Urban Design Review Panel Report

500 Coventry Road, Ottawa

December 12, 2025

**RE: Urban Design Review Panel Report
Site Plan Control Application
500 Coventry Road, Ottawa**

DRAWING NO: SPA005B
REV: 5

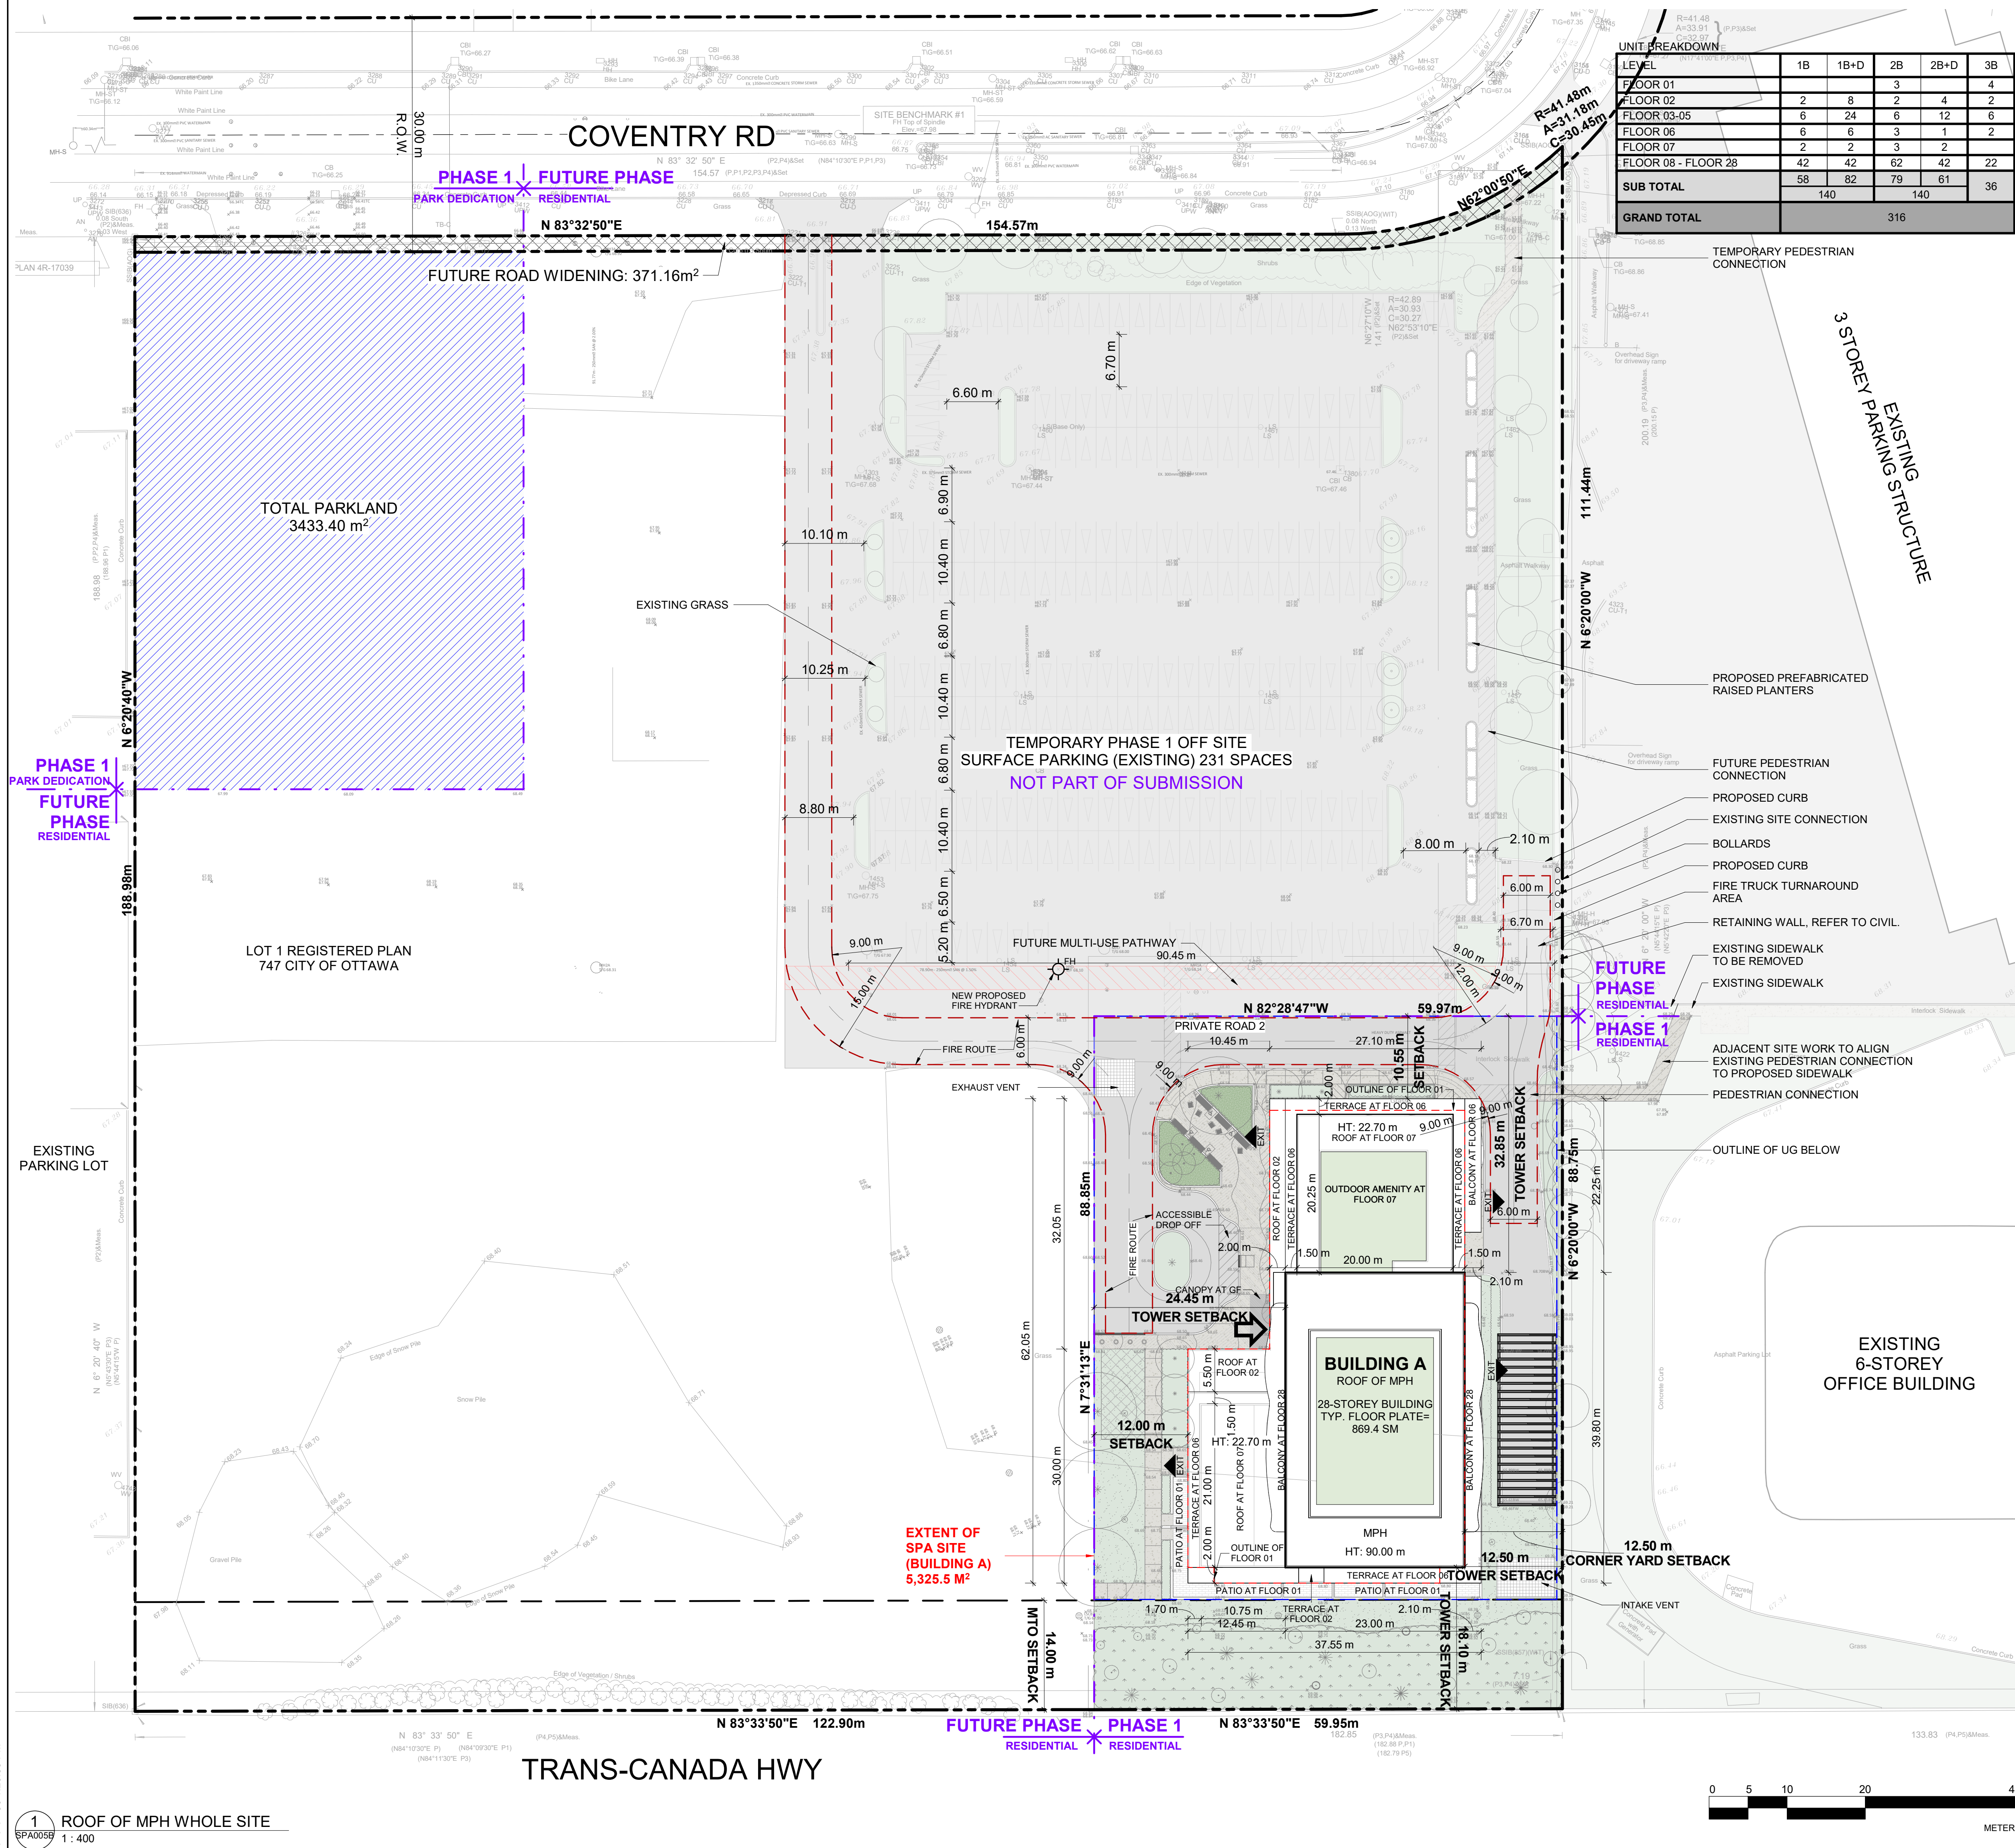
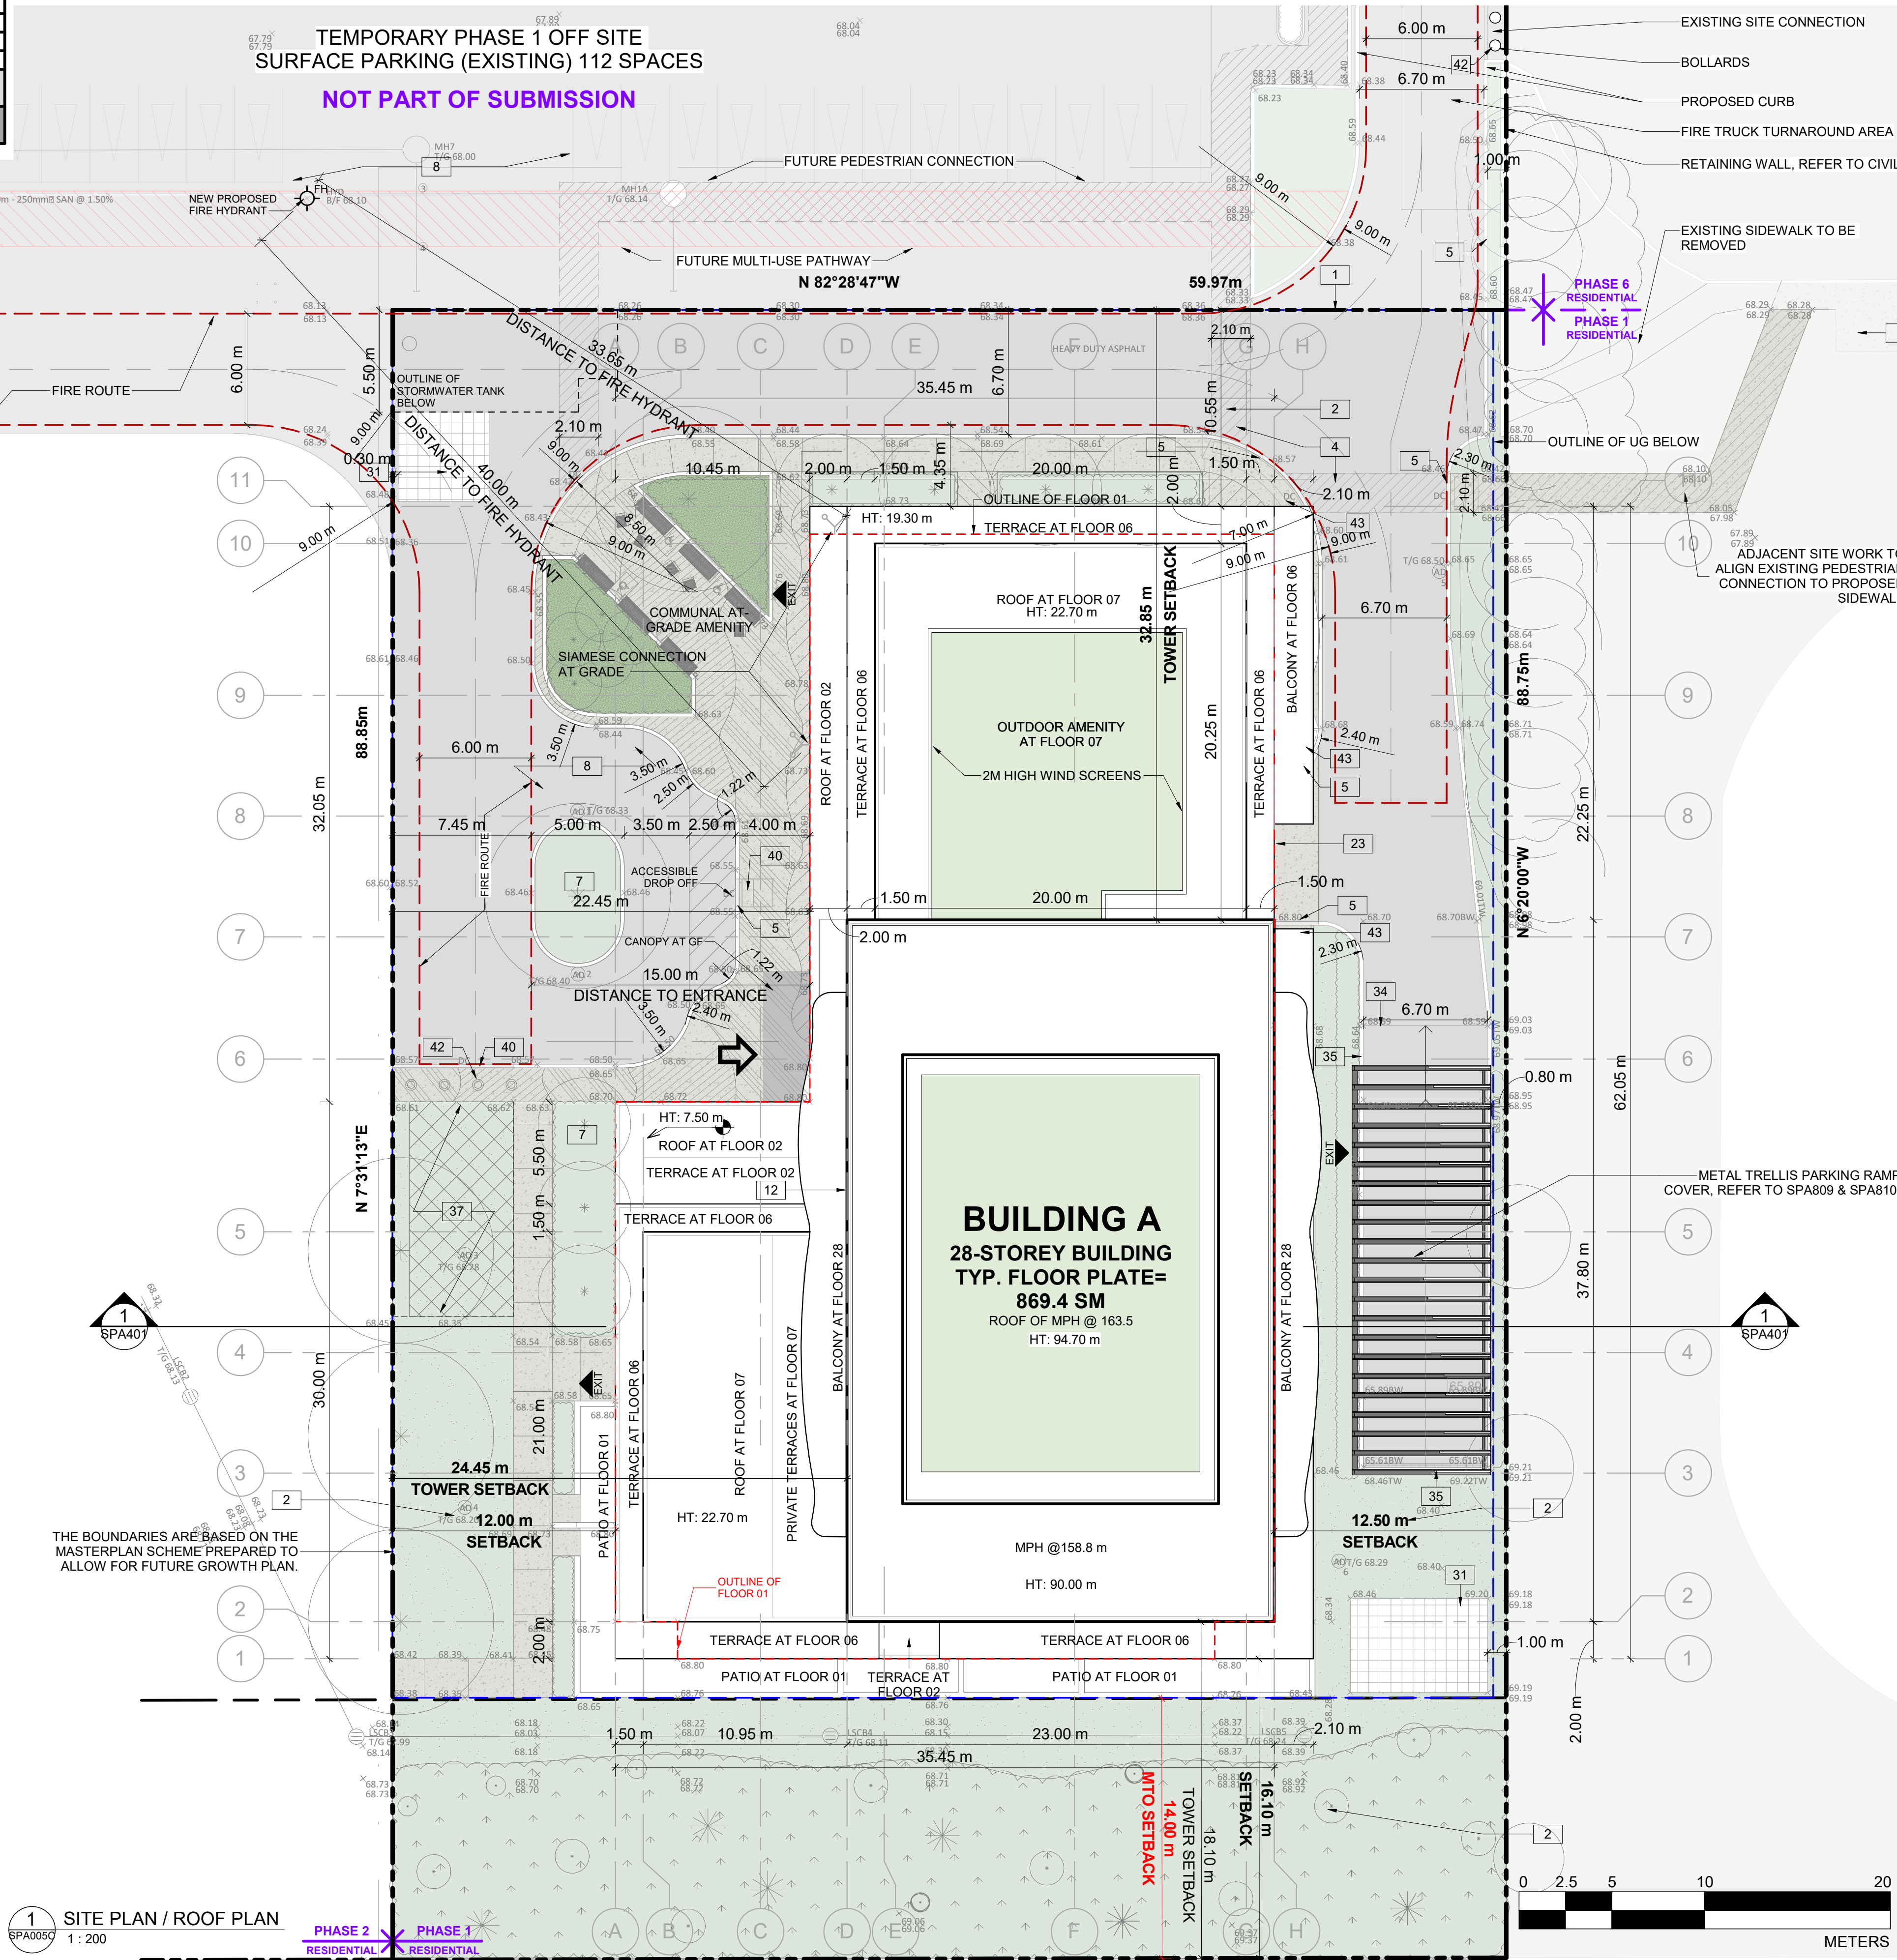
24. The Panel recommends further exploring ways to mitigate a sense of isolation for the first building in the interim.

- Consider how best to integrate the building with its surroundings prior to the rest of the build out of the site.

Response: The site plan has been developed to include pedestrian connection from public and to adjacent site. Landscape and grade have been coordinated to tie in with existing condition, providing smooth flow for pedestrians, cyclist and vehicle. Refer to SPA005B, C.
